**CITY OF PORTLAND, MAINE  
DEVELOPMENT REVIEW APPLICATION  
PLANNING DEPARTMENT PROCESSING FORM  
DRC Copy**

2004-0232  
Application I. D. Number

**Lot 2 Heritage Court**  
Project Name/Description

**Approval Conditions of DRC**

SITE PLAN LOT 2

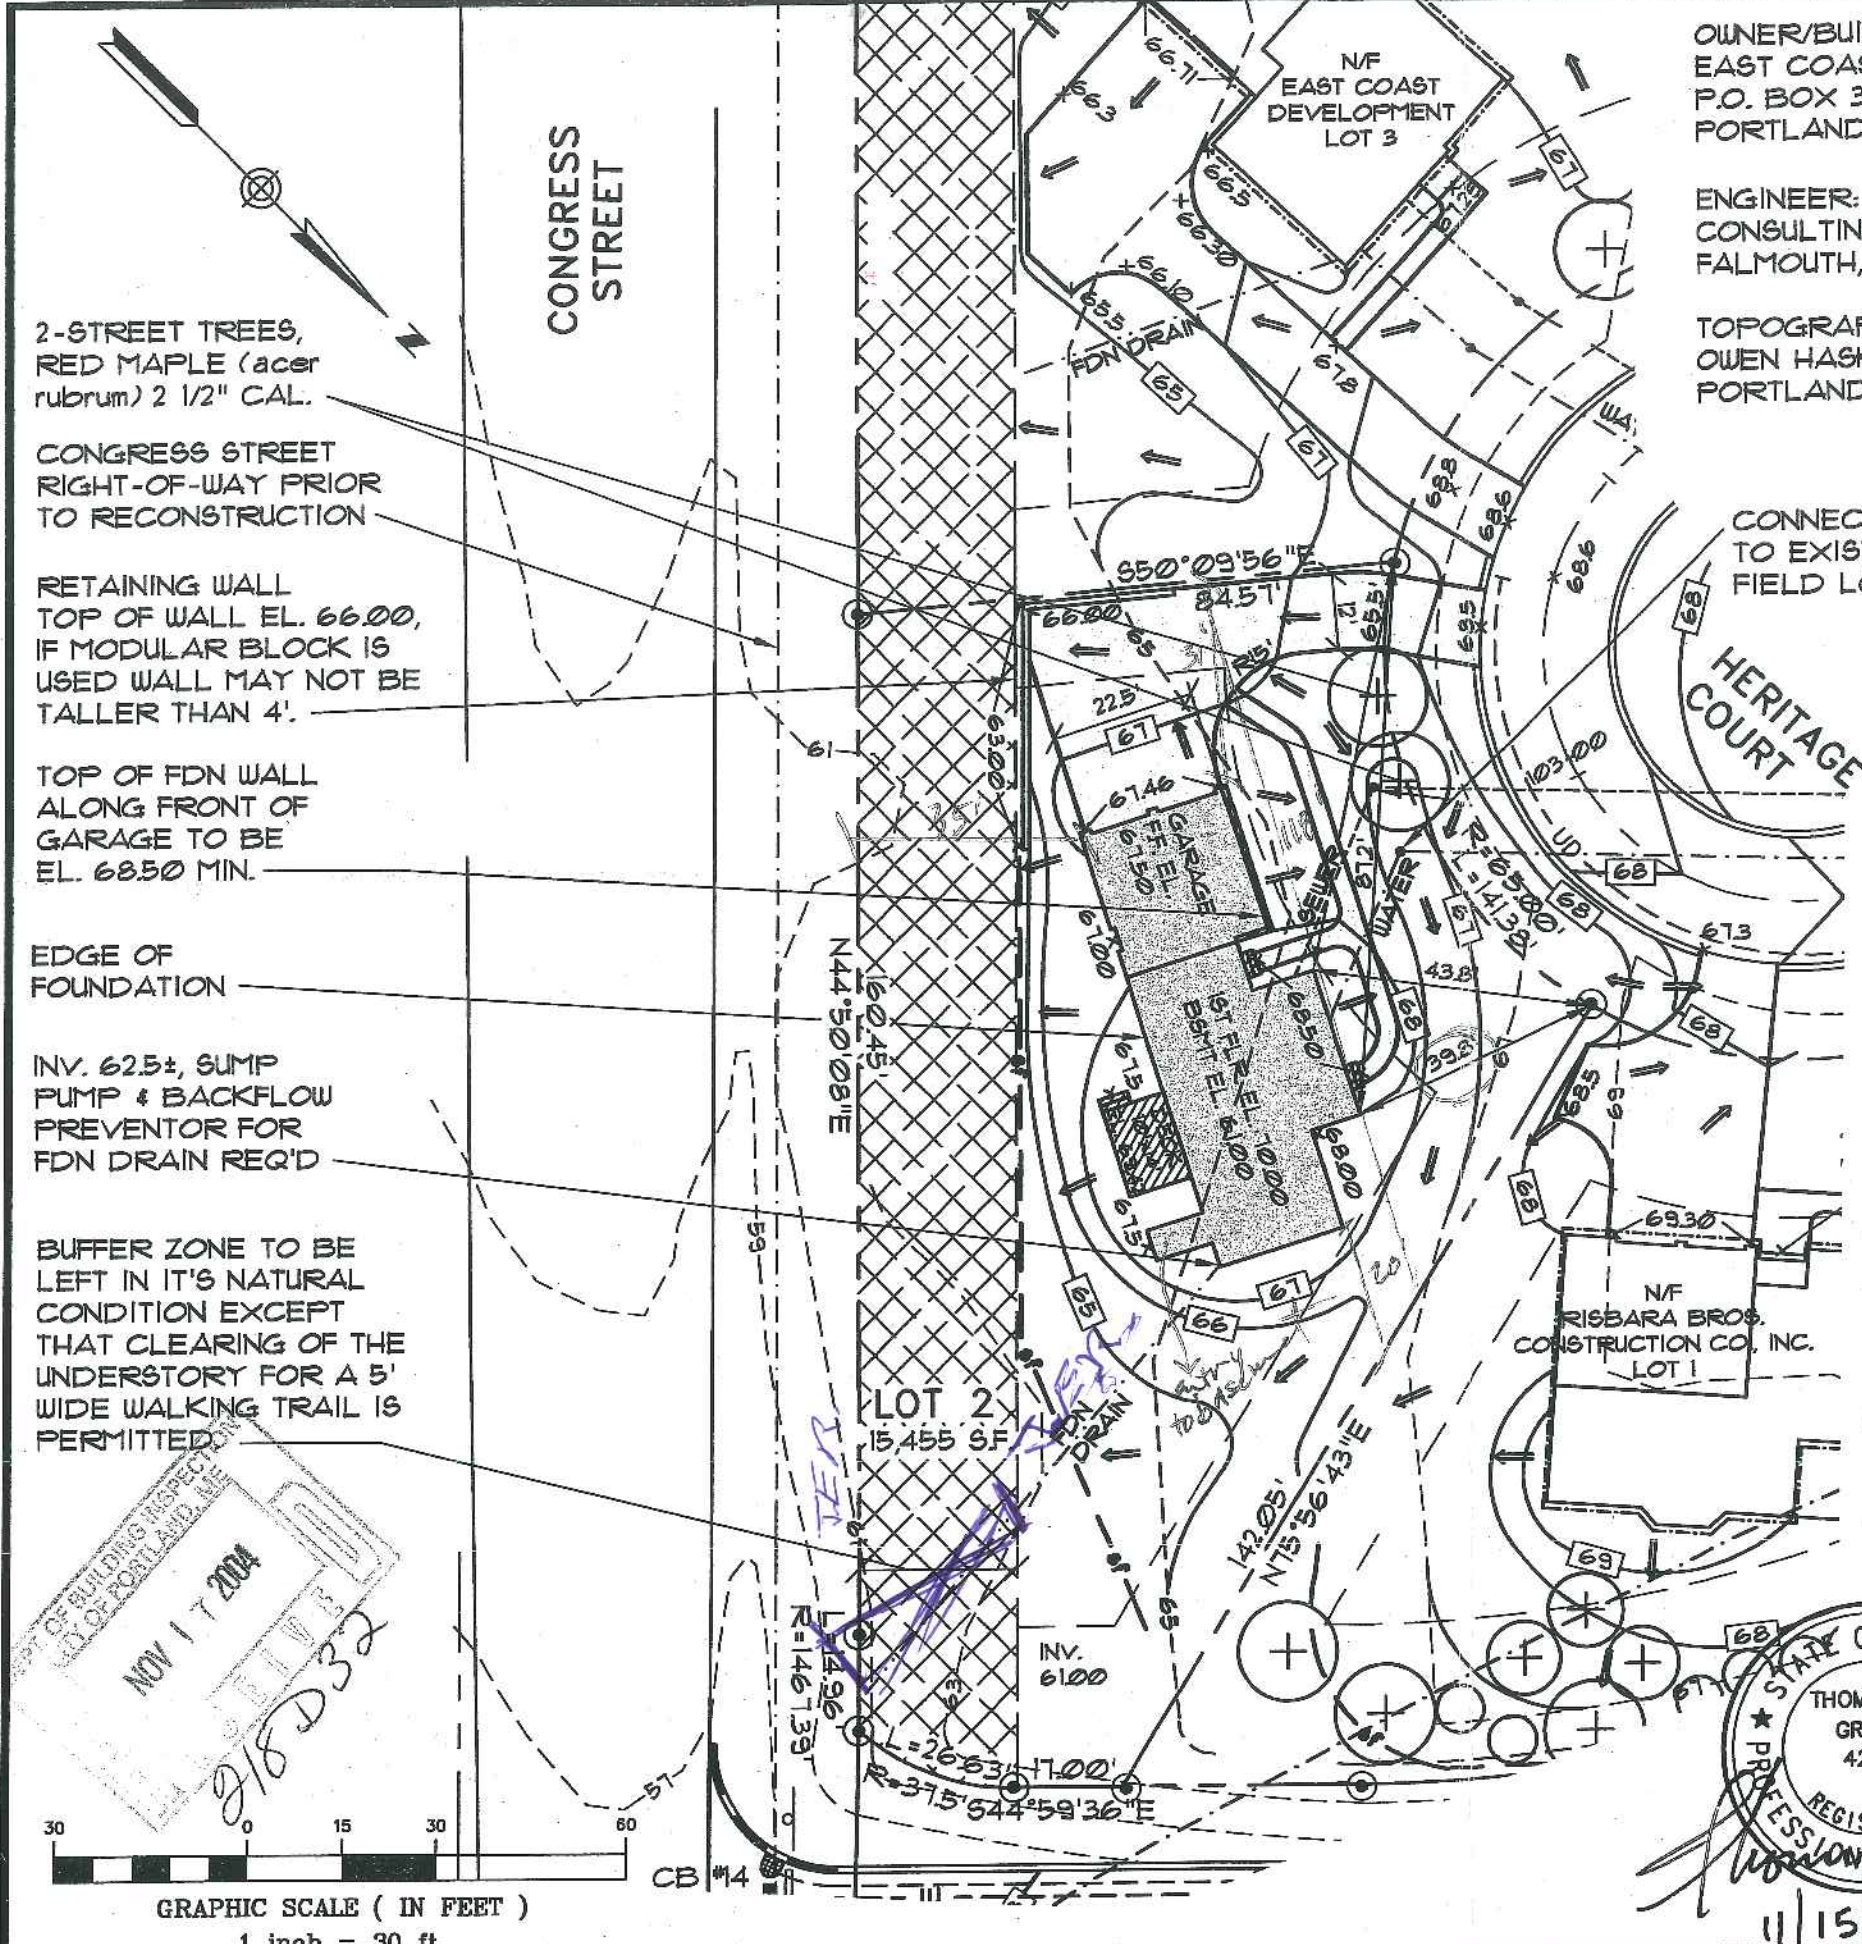
- 1 Buffer zone shall remain in its natural condition; Foundation drain shall not be installed within the existing buffer zone.
- 2 Final landscaped buffer solution to be worked out at an on-site meeting with Deb Andrews and Jay Reynolds upon completion of house construction.

① Add L.S. to Unincorporated Area Per HP Recommendation  
 ② All PD out of Unincorporated Zone

SF = 9,024.77  
Sump to Sewer Not Allowed  
Visit for PPE + Drainage  
New PL ok, merge?
